(ES/102/17/12) Condition 11

I am contacting you in regards to the development at Toddington Lane (LU/162/17/PL) and condition 14. In your comments on 15th October 2019 you asked for A visibility splay of 2.0m * 66m in both directions at the western end of the proposed footway. This was to ensure any pedestrians crossing in this location have sufficient visibility to see any oncoming cars. The 66m visibility splay is achievable looking west but not looking east.

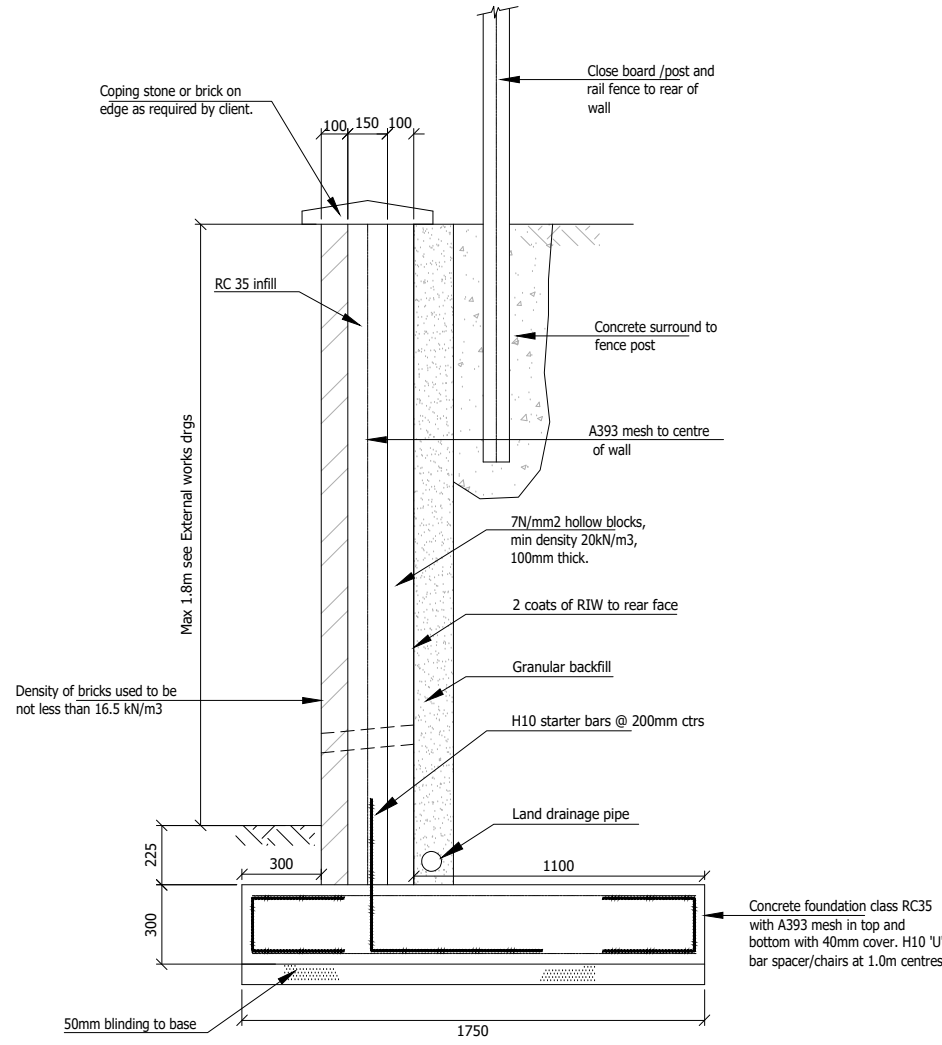
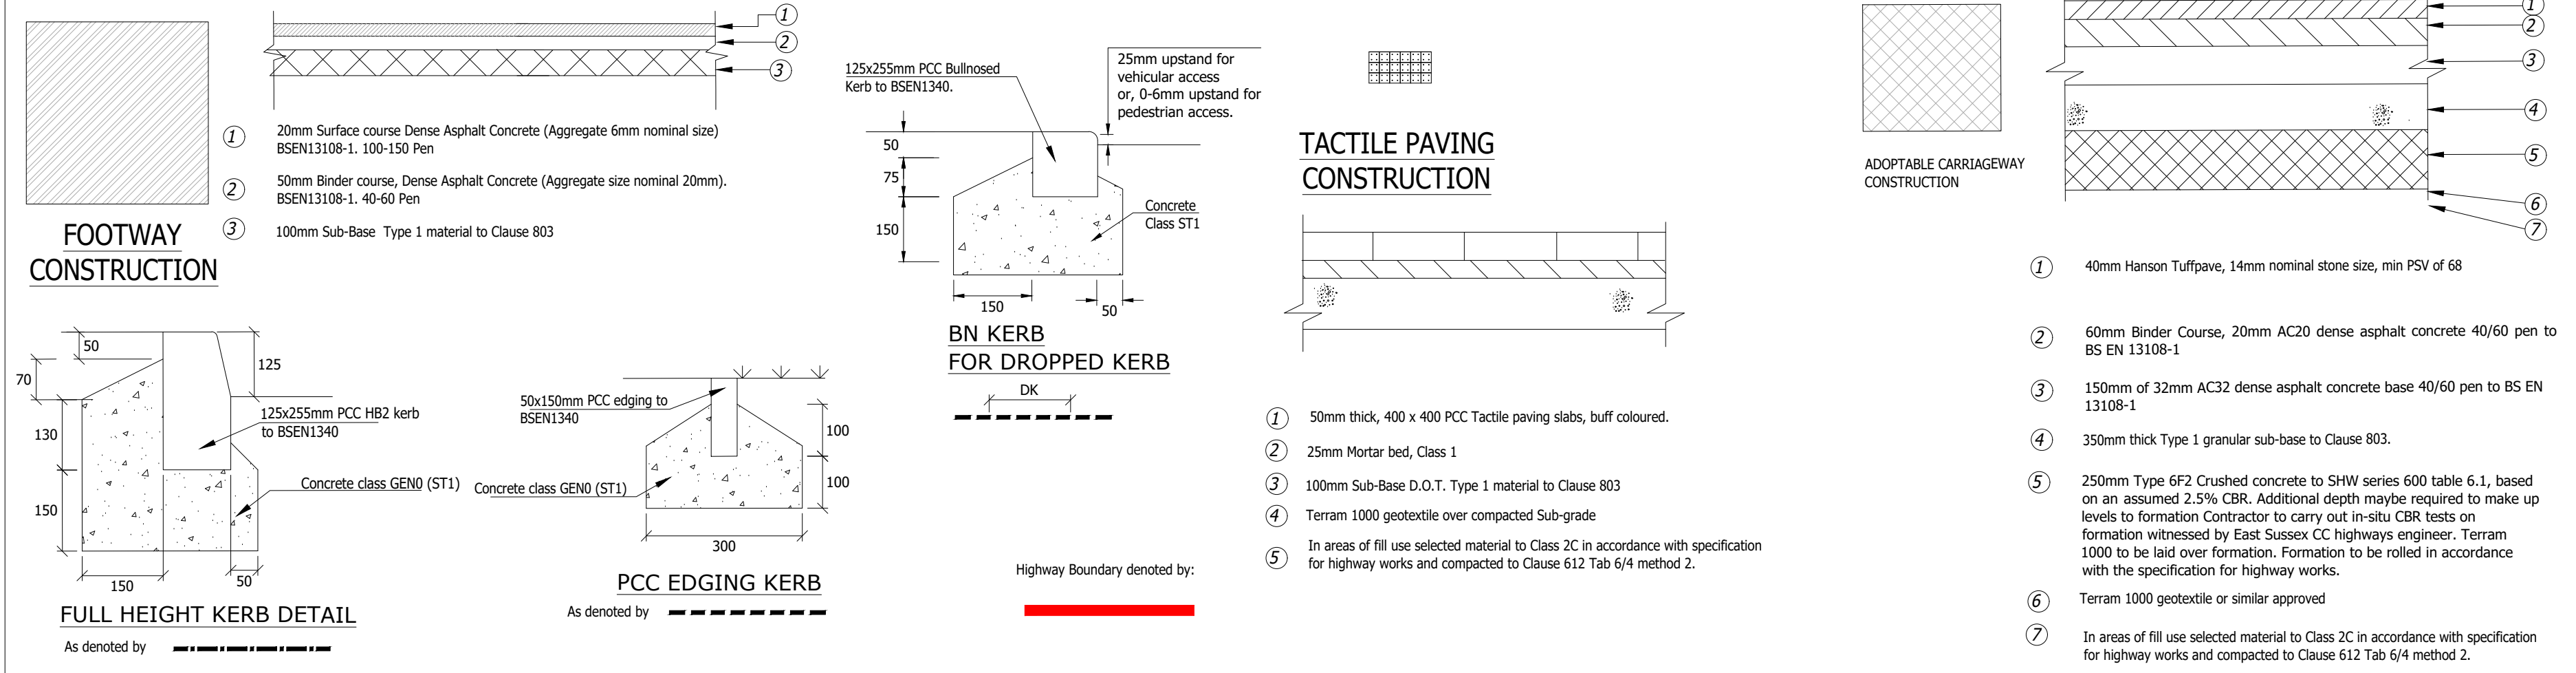
In order to ensure that the visibility splay looking west is entirely within highways land we can only guarantee a 59m visibility splay. In regards to this I would refer to my email to Tim from 19th November:

"I note that section 4 of WSCC design guide states that lightly trafficked residential roads have 85thile speeds below 37mph, can have MfS1 standards applied. As this is the case for Toddington Lane, the 66m visibility splay is likely in excess of the stopping sight distance for westbound vehicles will need to see pedestrians. Using MfS1 standards and the recorded 28mph 85thile speed there is a stopping sight distance requirement of 39m."

As such I would contend the 59m visibility splay entirely within the highway boundary should be acceptable.

In principle I think we could accept the 1 metre. However just one point I would like to confirm, the 66 metre splay to the west can you confirm in a bit more detail it is all contained within highway land as it present it is not stated.

I also note that the visibility splay asked for is from 2.0m, the proposed footway is 2m in width and it is unlikely a pedestrian would be stood on the back edge of the footway, would a visibility splay from 1.0m be acceptable as this is likely to be more reflective of a pedestrians position on the footway.

With the above in mind I would suggest a 1.0m * 39m visibility splay should be acceptable and allow for the crossing point to function safely. Please see update site layout with the visibility splays, I have shown 66m looking westwards as this is achievable and 39m is achievable looking east. Please note I have shown the 39m visibility splay to 600mm off of the kerb to represent the likely position of a car.
